Engineers Comments Regarding Surface Water Drainage

Application Reference:	Y/19/25/DOC	Reviewer Reference:	ADC/EXT12/GK
Planning Officer:	Simon Davis	Date of Review:	16.06.2025
Site Name:	Land North of Yapton C of E Primary School North End Road Yapton		
Application Description:	Approval of details reserved by condition imposed under reference Y/88/18/OUT relating to condition number 17 - surface water drainage system.		
Assessment Number:	1 of 2

Application Reference: Y/19/25/DOC Site Name: Land North of Yapton C of E Primary School North End Road Yapton	Initial Issue Date: Issue Date: 16.06.2025 Reviewer Reference: ADC/EXT12/GK
---	--

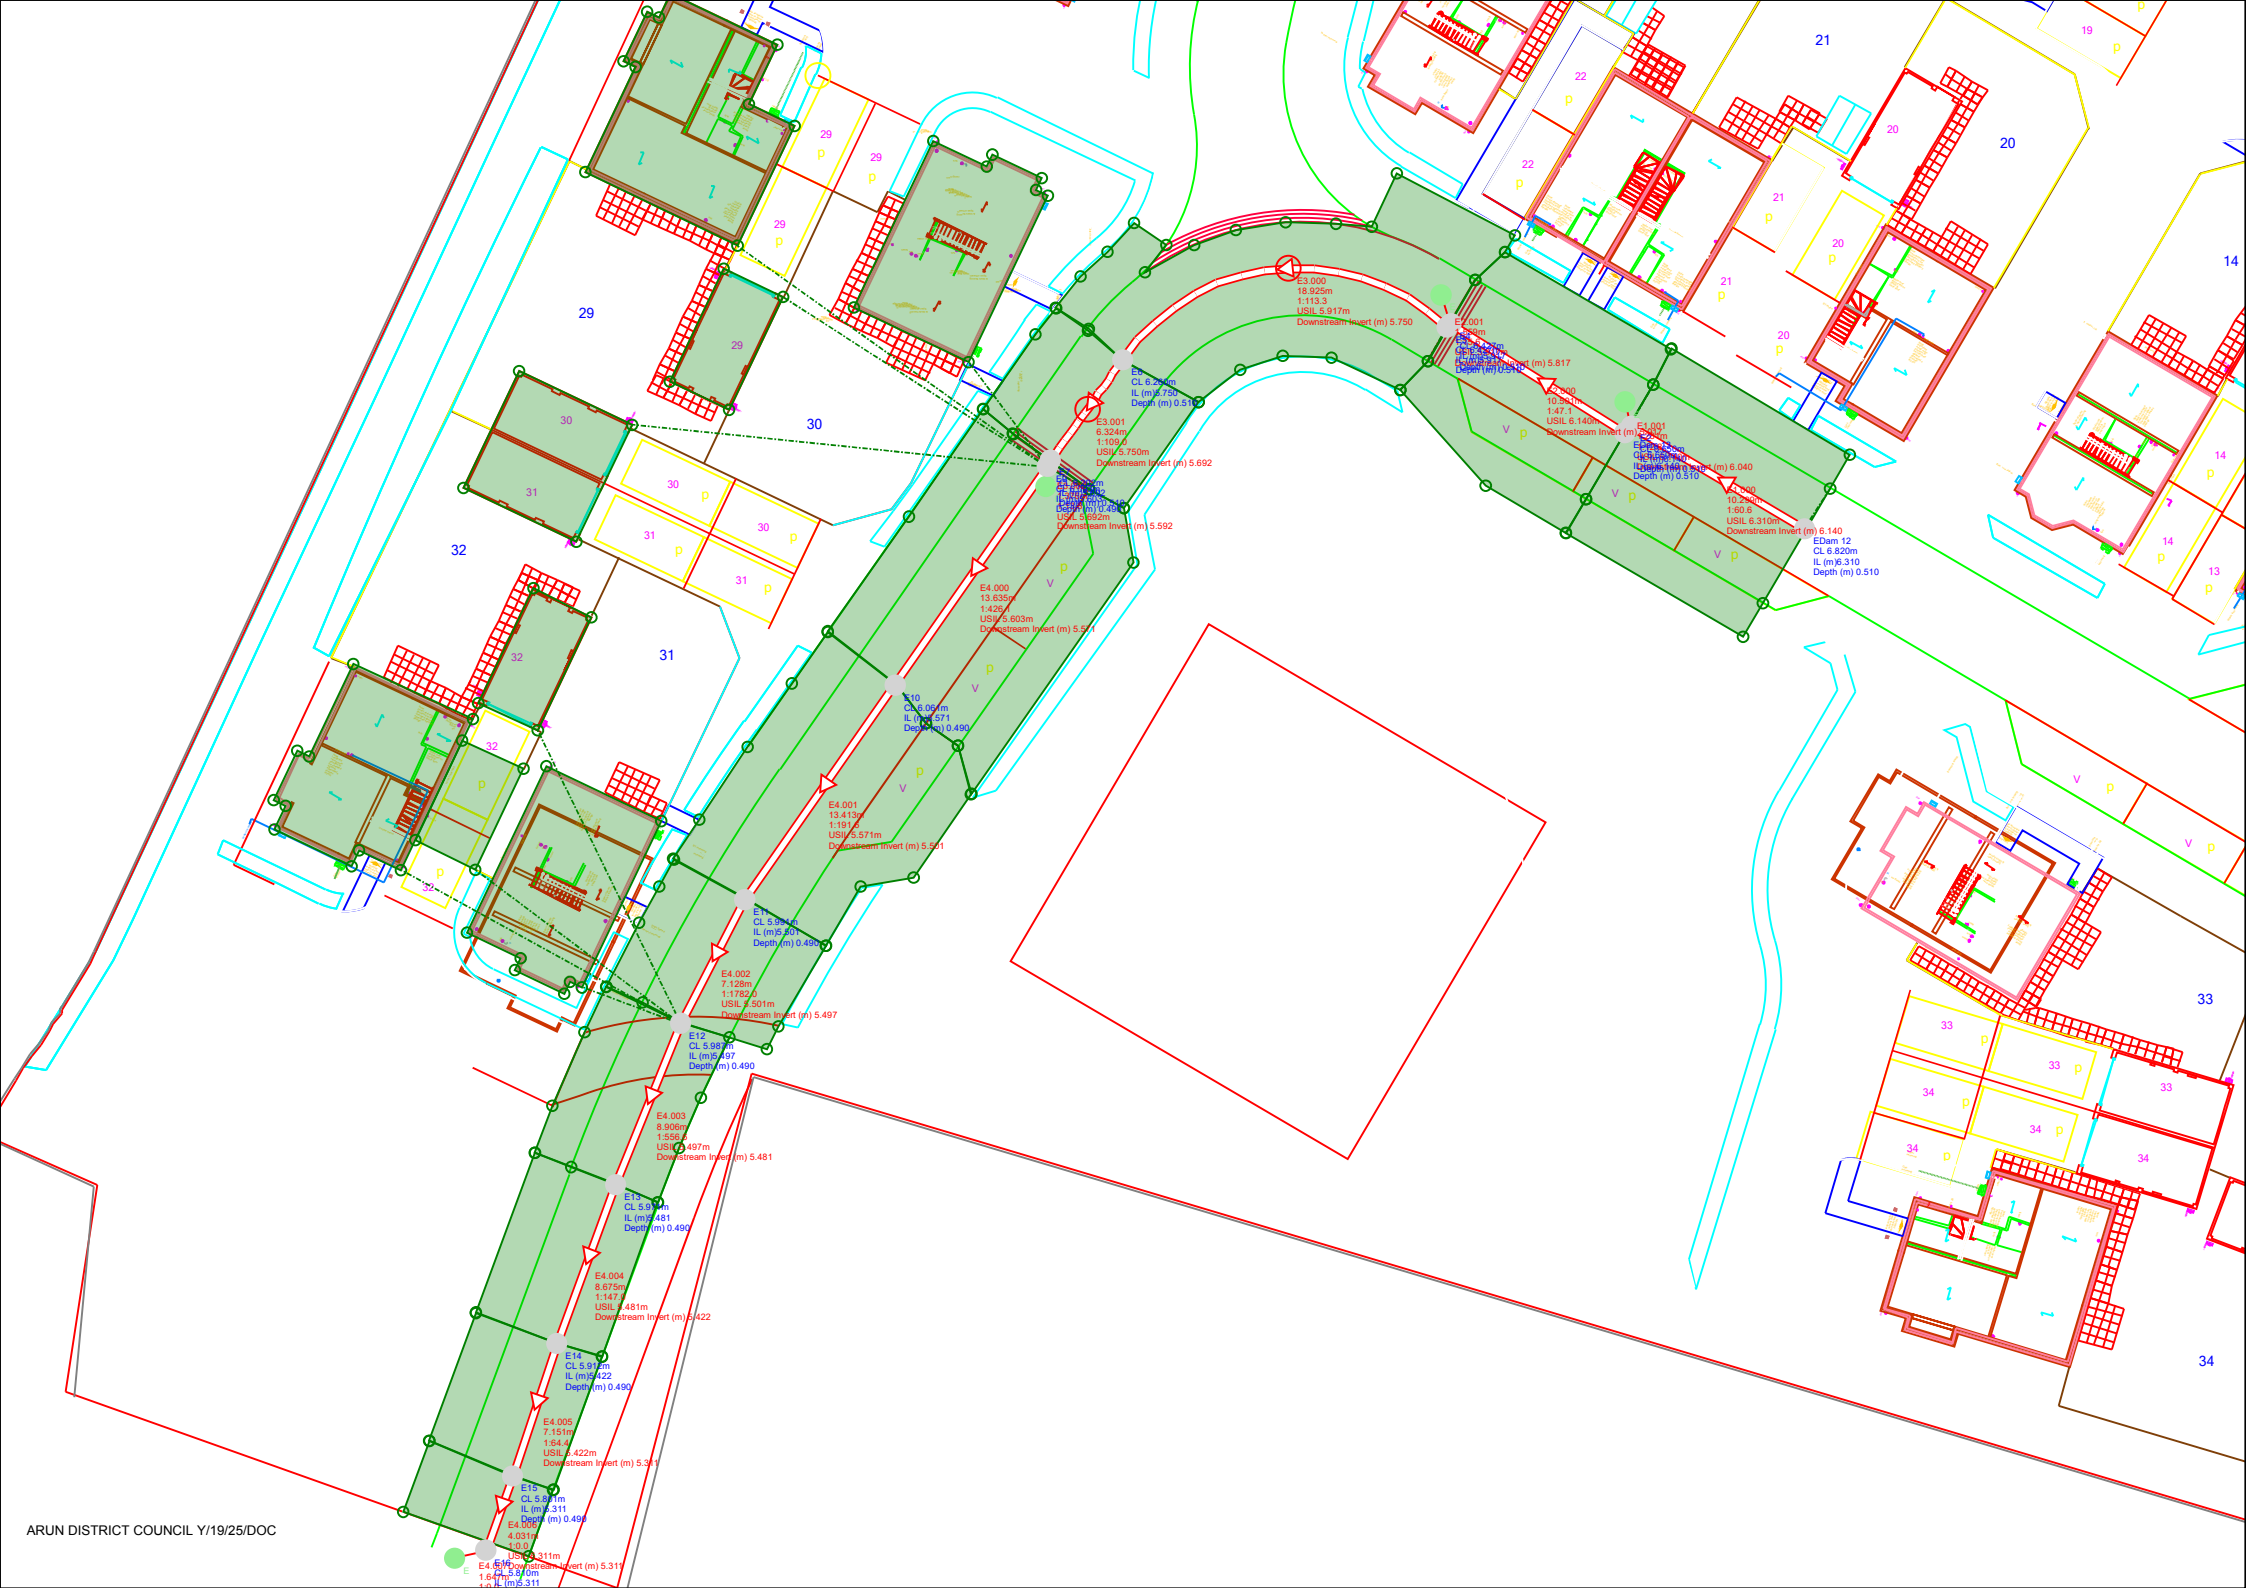
1.	Please provide the updated drainage calculations following receipt of the as-built survey. Also confirm that the very small flooding amount mentioned on paragraph 3.1.1 is routed within the site as previously agreed in the approved drawings.	The calculations based on the as-built survey were included in Appendix D of the Drainage Completion Report.	- CV value should be equal to 1. If a different value has been agreed, please provide the relevant evidence. - Please also provide half drain times for the 1 in 10y + CC and 1 in 100y + CC storms. - We understand that the flooding calculated is minimal however this amount might be higher with the CV equal to 1. Please provide a drawing explaining how the flooding will be tackled. If this has been previously agreed, please provide the relevant evidence.	Even though there is satisfactory explanation regarding the minimal amounts of flooding the calculations should be updated in accordance with the previous comment. Comment remains.

AS-BUILT (38 UNITS)
PERVIOUS PAVEMENT SUB-GRADE

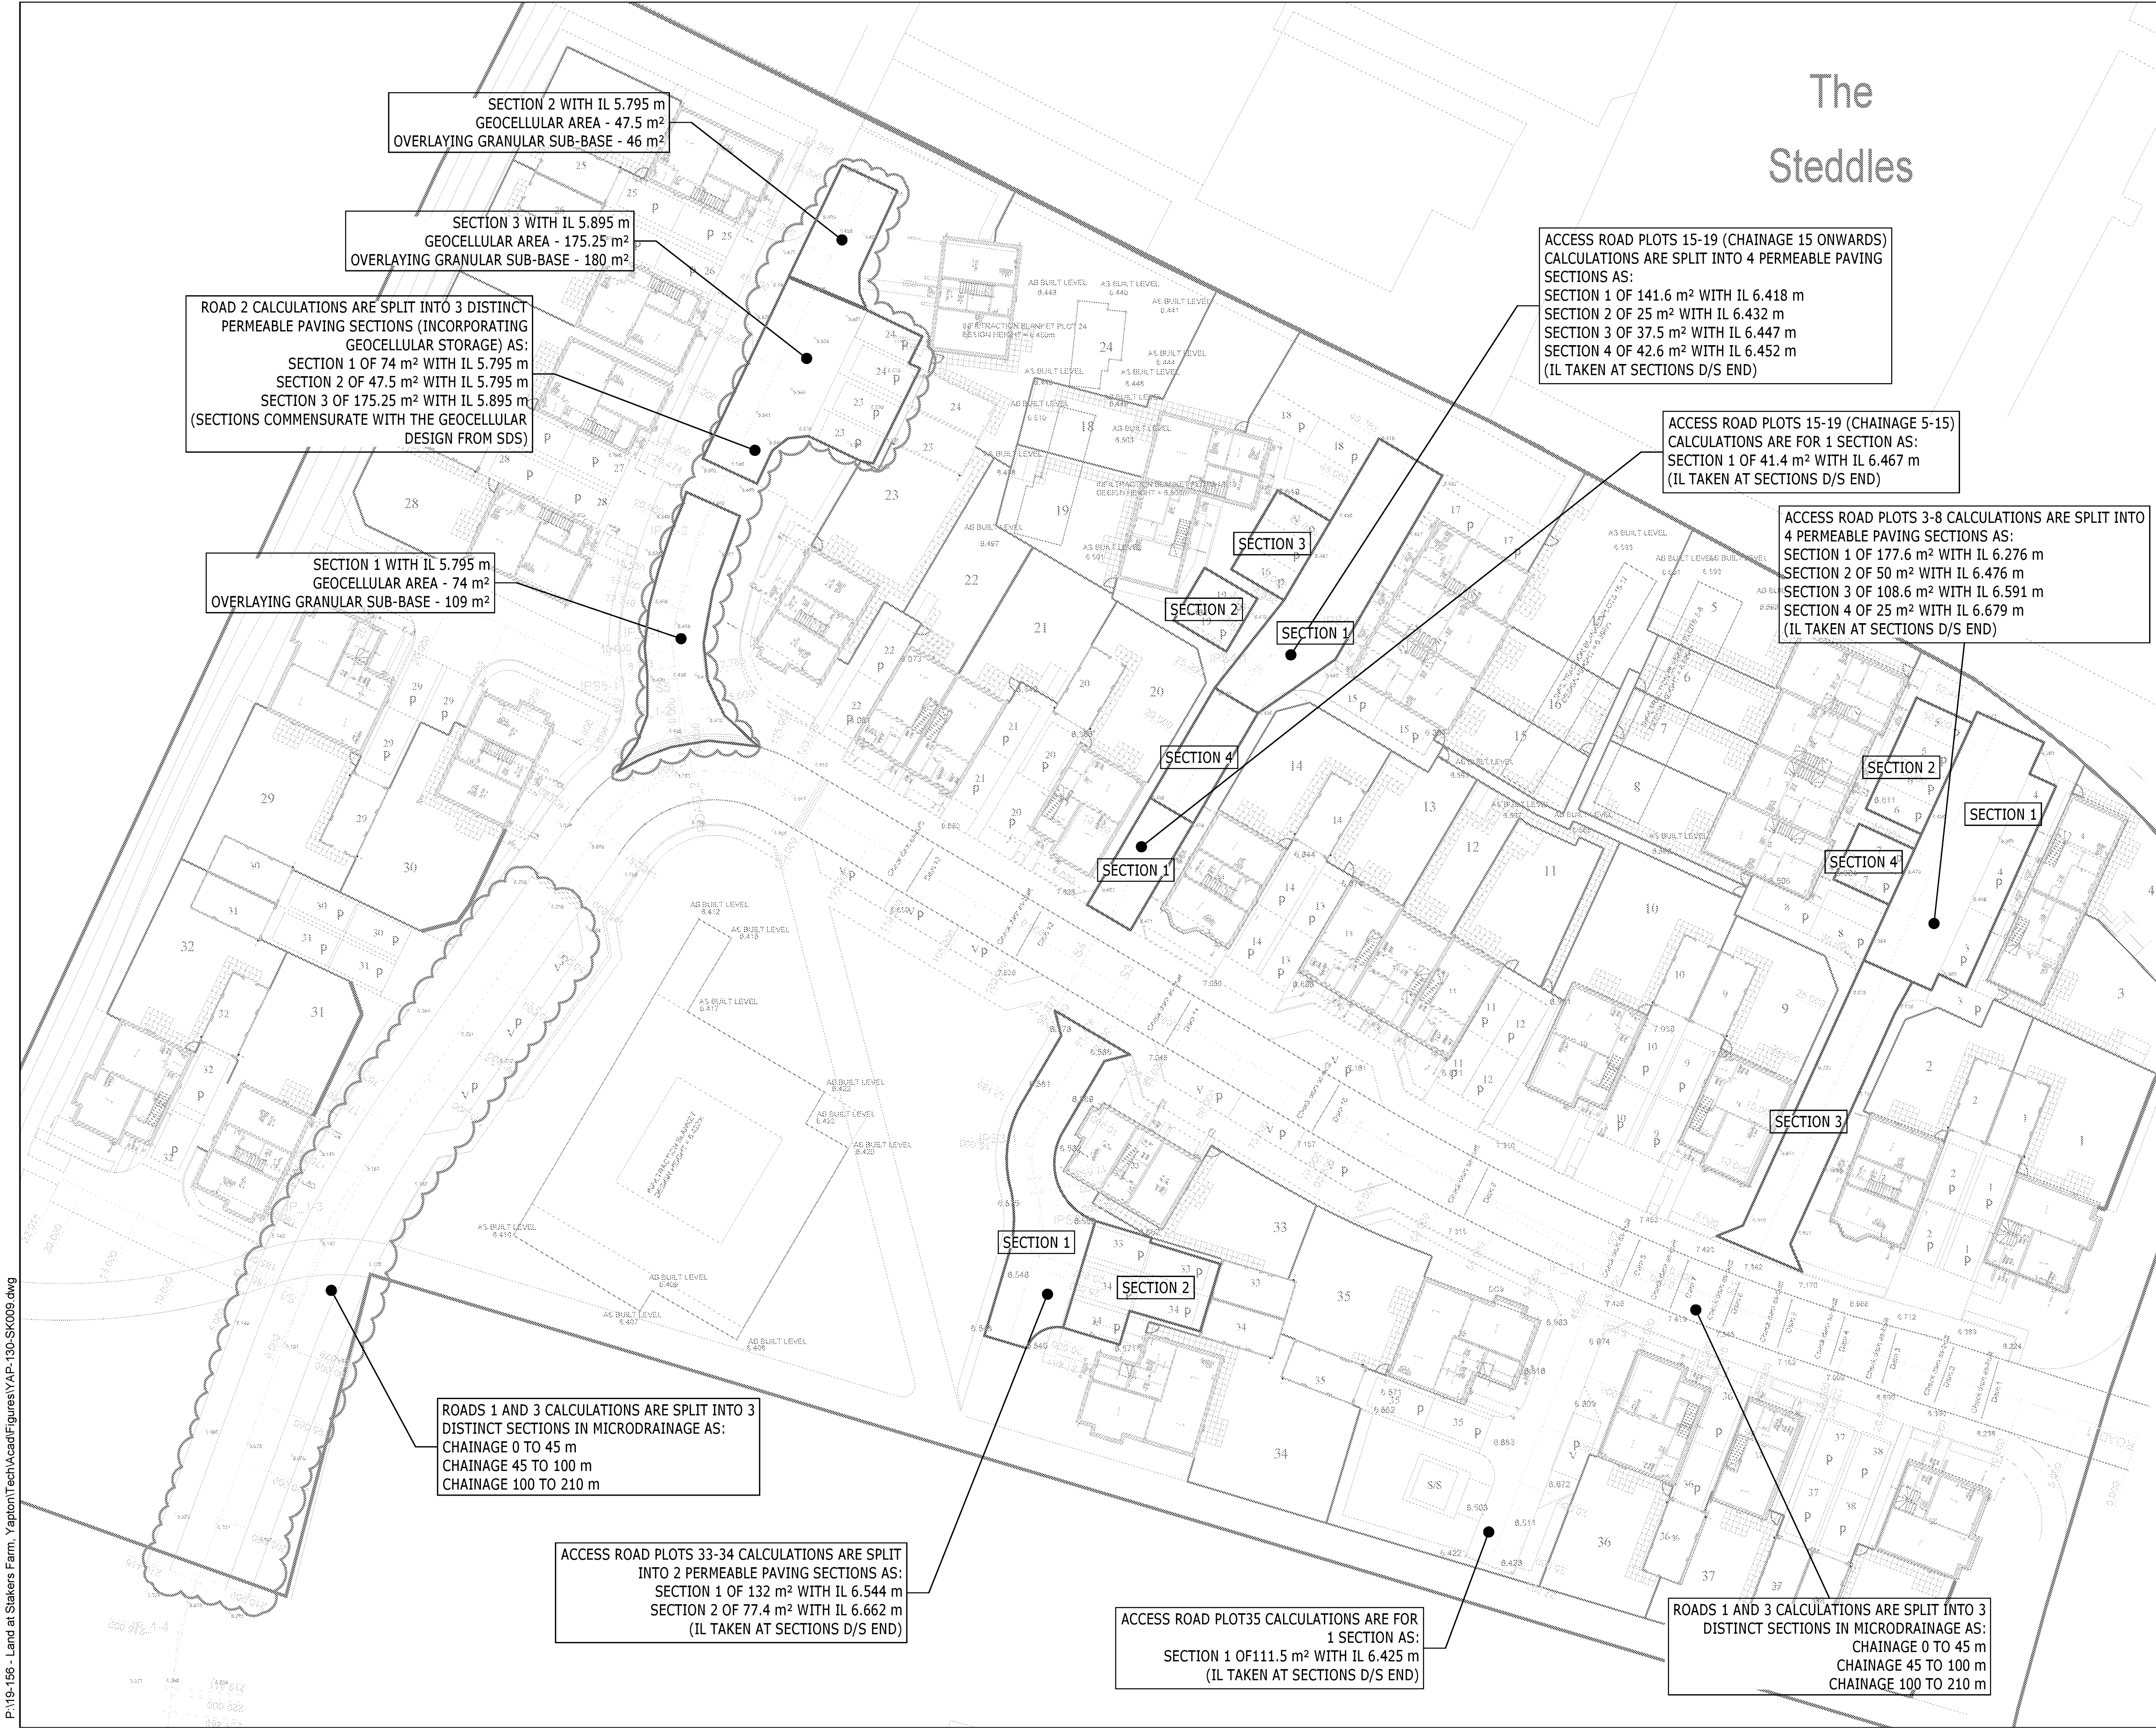
6.	On the as-built drawing please provide as-built details for all the infiltration blankets their base level, their height, cover level and plan dimensions. (Copy information from Appendix G)	This has been given already for the sections in open land, those within private owned land we cannot obtain which was accepted some time ago.	Agreed and closed

MH S72 - SILT TRAP

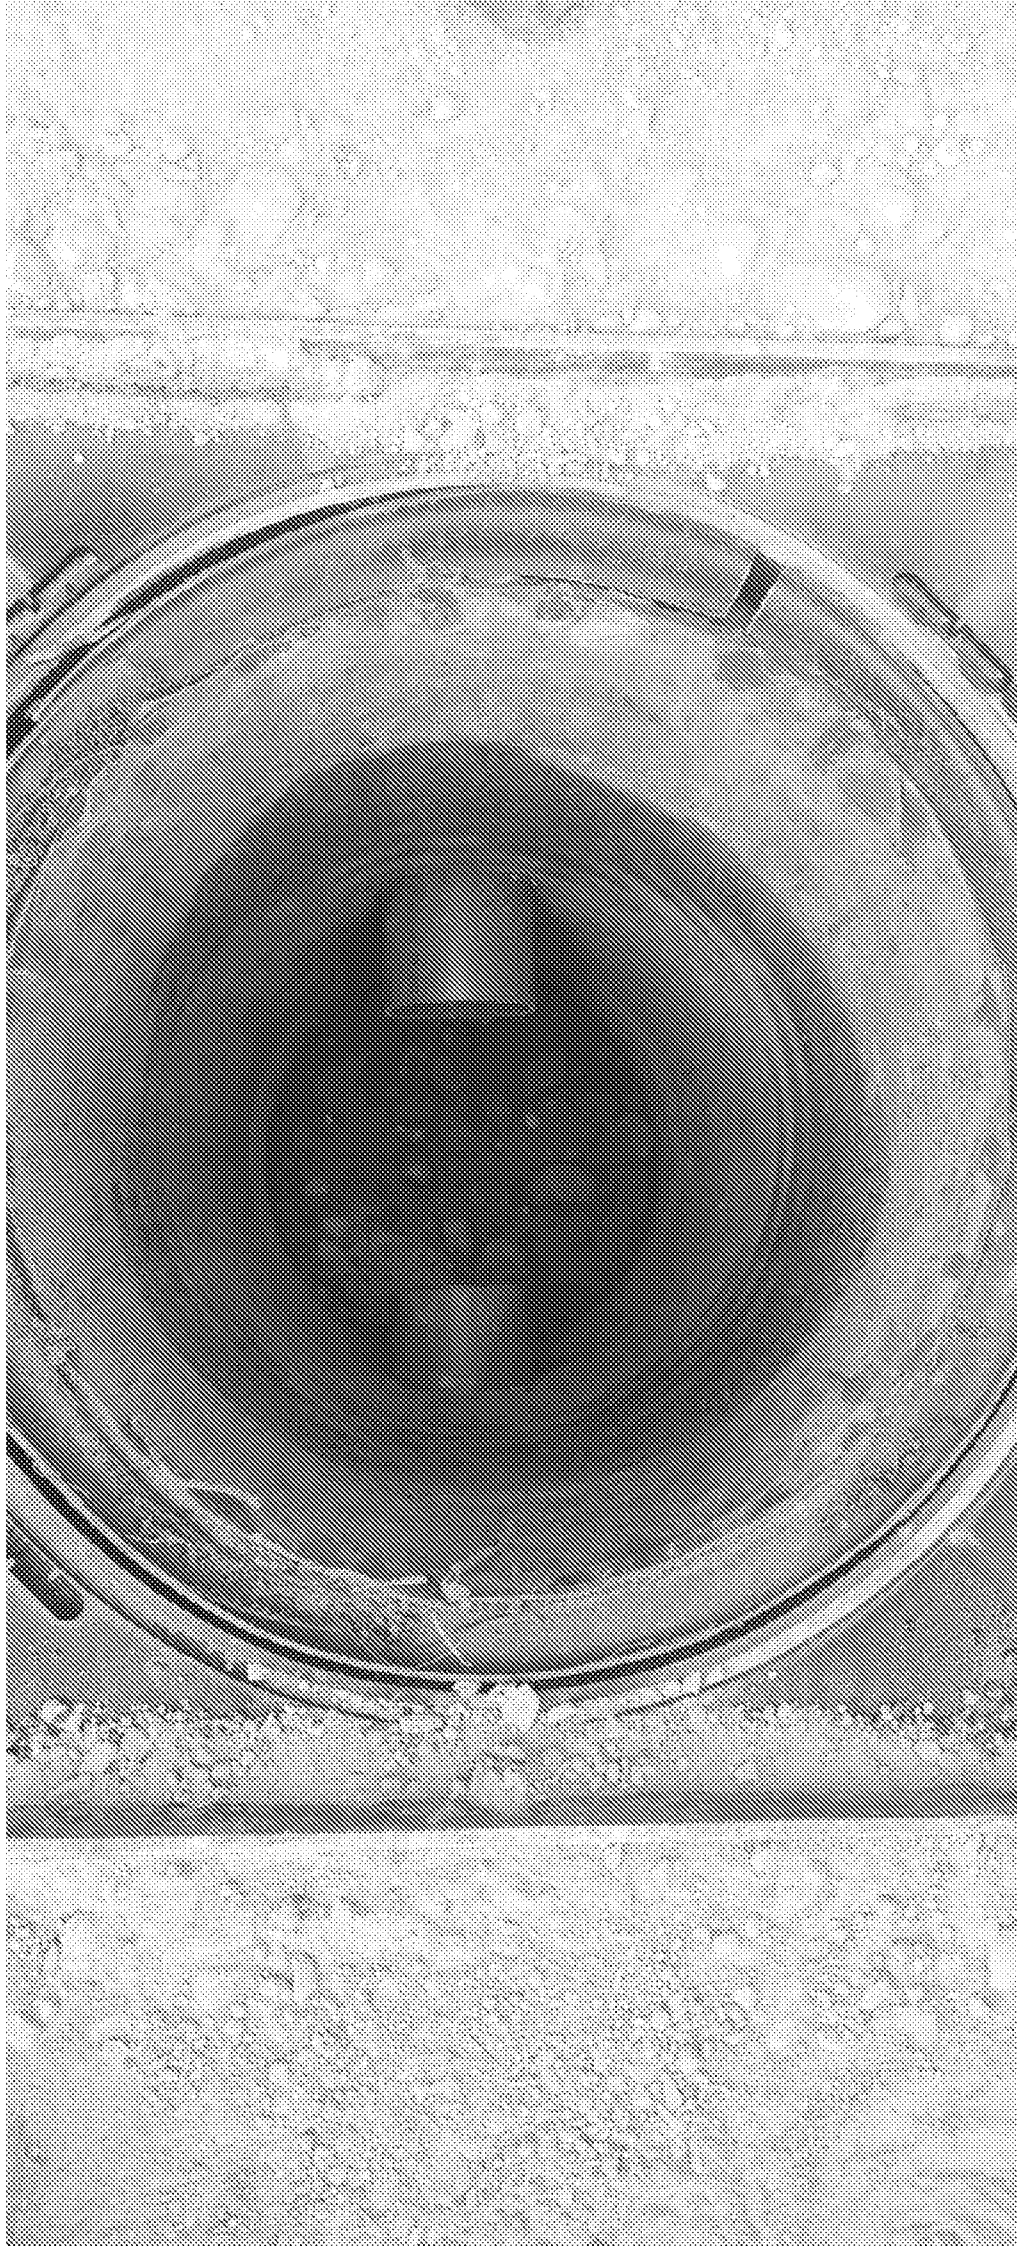
- MH S72: - Specified as silt trap with 300mm sump but not conventional silt trap constructed (ie. benched) and also doesn't look like it achieves the 300mm. - The twin incoming pipes have been constructed as 150mm diameter as opposed to 225mm diameter. - The outlet is a single 150mm diameter – should have been two 225mm diameter outlets I believe. The outlet to MH S74 does not exist and hence MH S74 does not exist either. - Infiltration tank west of Plot 33: - The proposed access manholes (5 no.) to provide a means of inspection into the crates appear not to exist. - Manhole S70: - Outgoing pipes twin 150mm diameter as opposed to 225mm diameter. - Incoming pipe from north 150mm diameter as opposed to 225mm. - Incoming pipe from east 225mm diameter as proposed. - Manhole S69: 150mm diameter outlet as opposed to 225mm. 100mm diameter incoming from west as opposed to 150mm. - Manhole S73: - In different location to that shown on the plan. Please confirm if it contains a silt trap. - Permeable pavement west of plot 23; - Manholes not good construction ie. holes cut through walls to accommodate pipes. If to be retained, they will need cleaning out and making good around pipes with mortar. - Manhole S65: - In pavement as opposed to the location shown on the plans.
